# Net Zero Teesside Project

Planning Inspectorate Reference: EN010103

Notification of Proposed Changes to the Net Zero Teesside DCO Application

Date: 18 February 2022

KEY PLAN
Scale 1:20,000

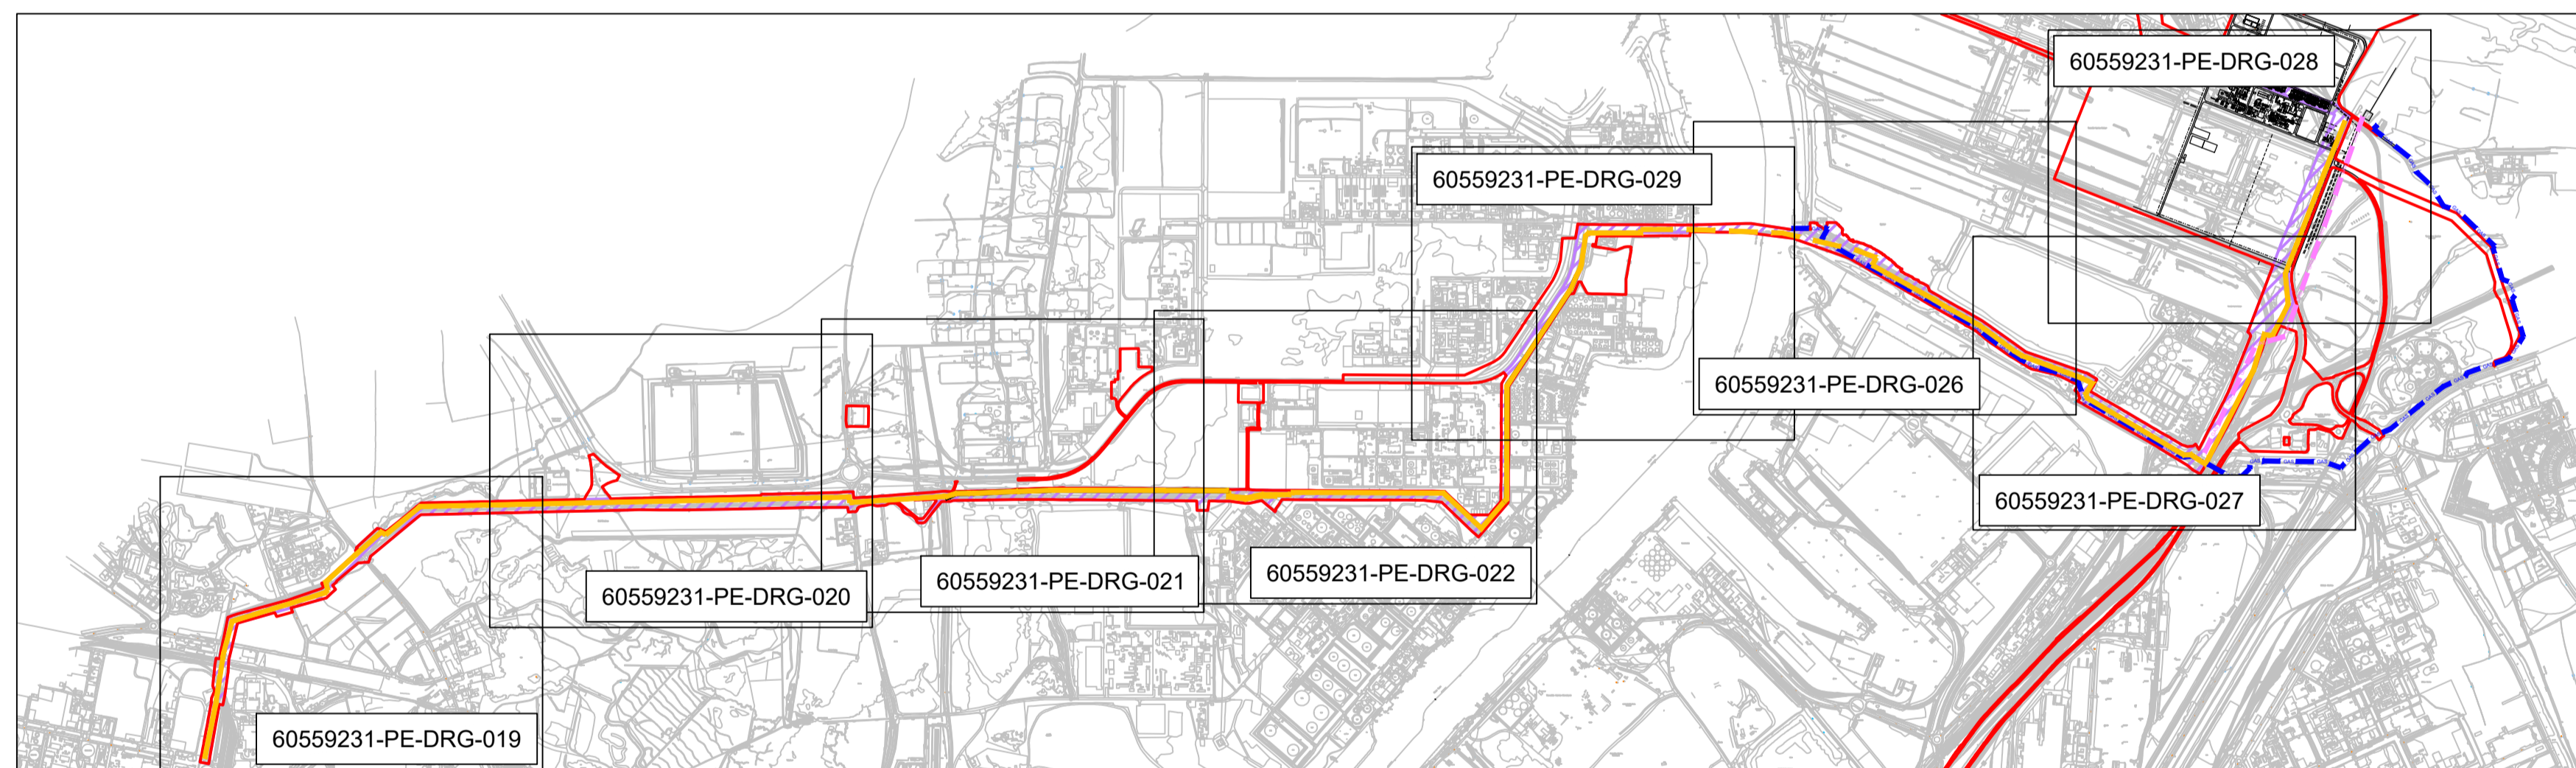
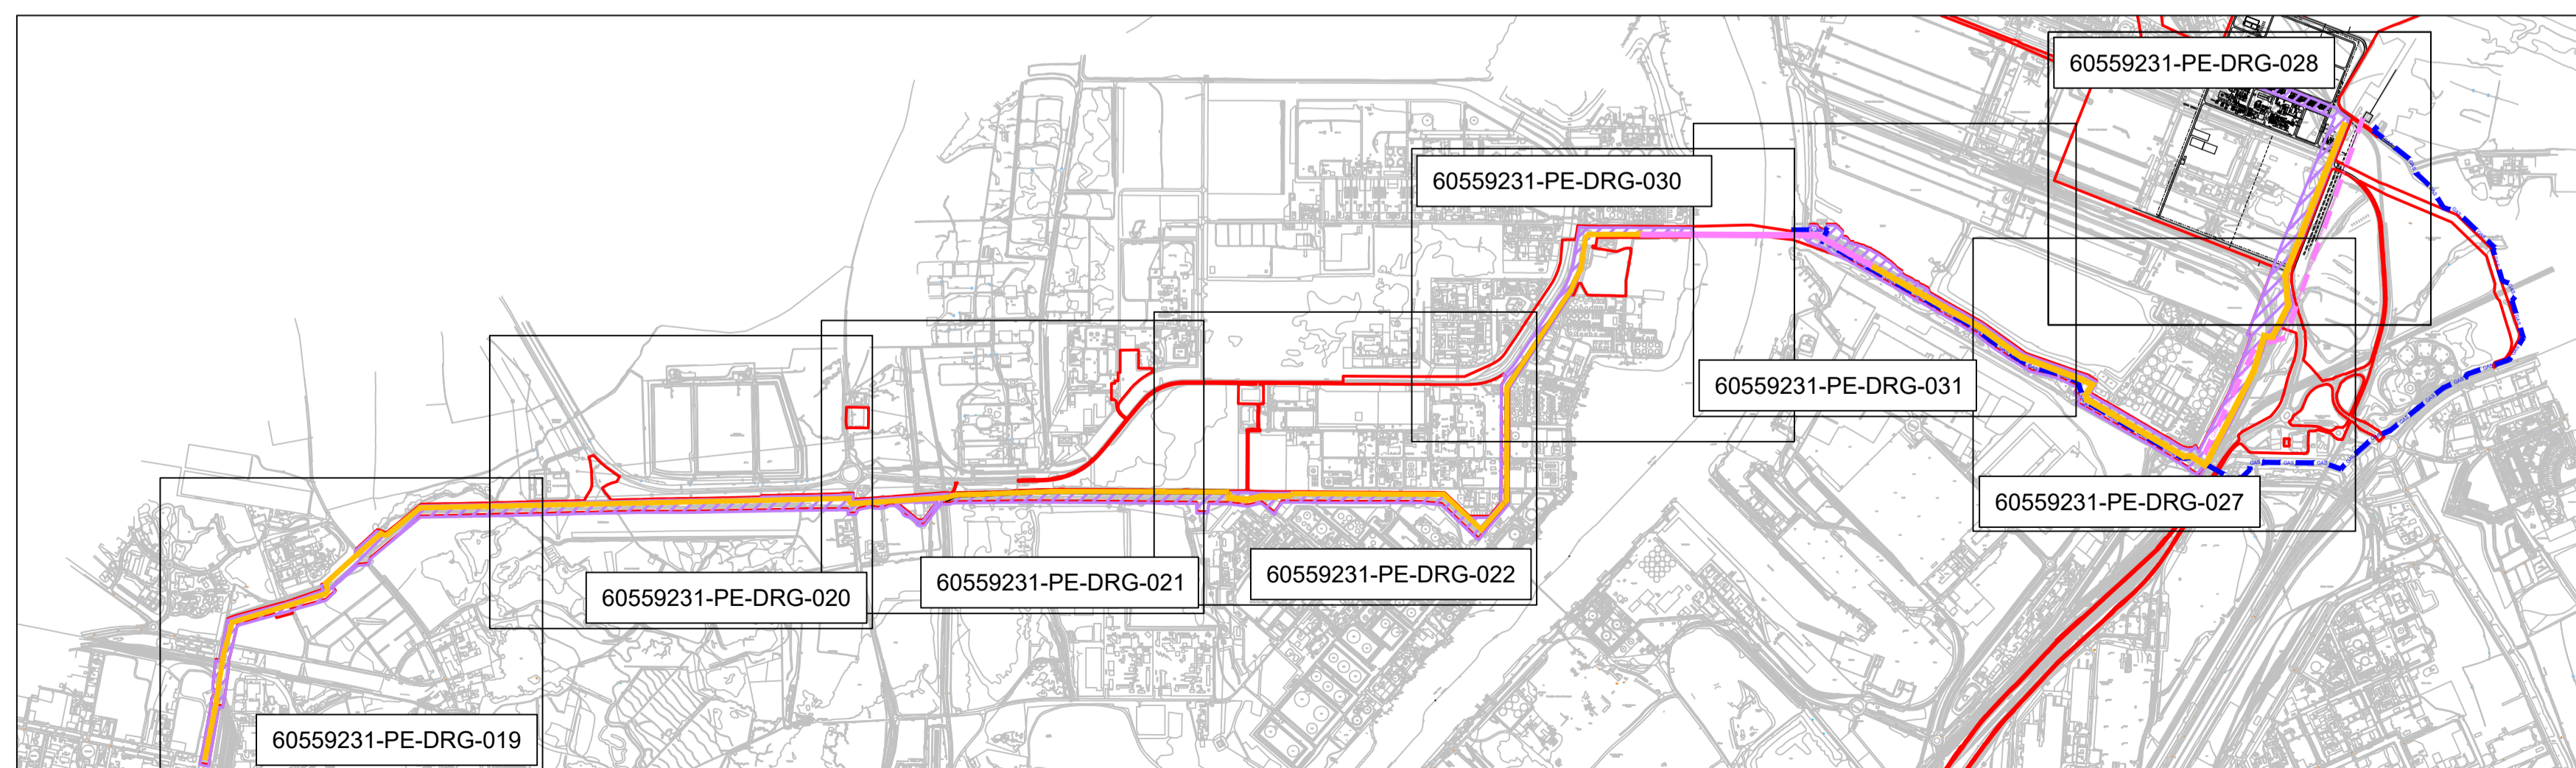
- 2.3.10 The changes propose two revised options for the CO<sub>2</sub> Gathering Network's crossing of the Tees:
  - Option 2 (HDD and connection via Dabholm Gut): the option of an HDD bore will remain within the DCO Application. However, a changed trajectory for the HDD bore used to allow the pipeline to cross the Tees now necessitates changing the direction that the HDD will be drilled and pulled from; and

- Option 3 (Sembcorp No 2 Tunnel): this is a new option that makes use of existing infrastructure in an existing Tunnel across the River Tees that is located within the existing corridor for the CO<sub>2</sub> Gathering Network (the 'Sembcorp No 2 Tunnel').

- the CO<sub>2</sub> Gathering Network corridor around Billingham and Seal Sands;
  - in the CO<sub>2</sub> Gathering Network corridor to the south-east of the NWL Brans Sands WwTW facility;
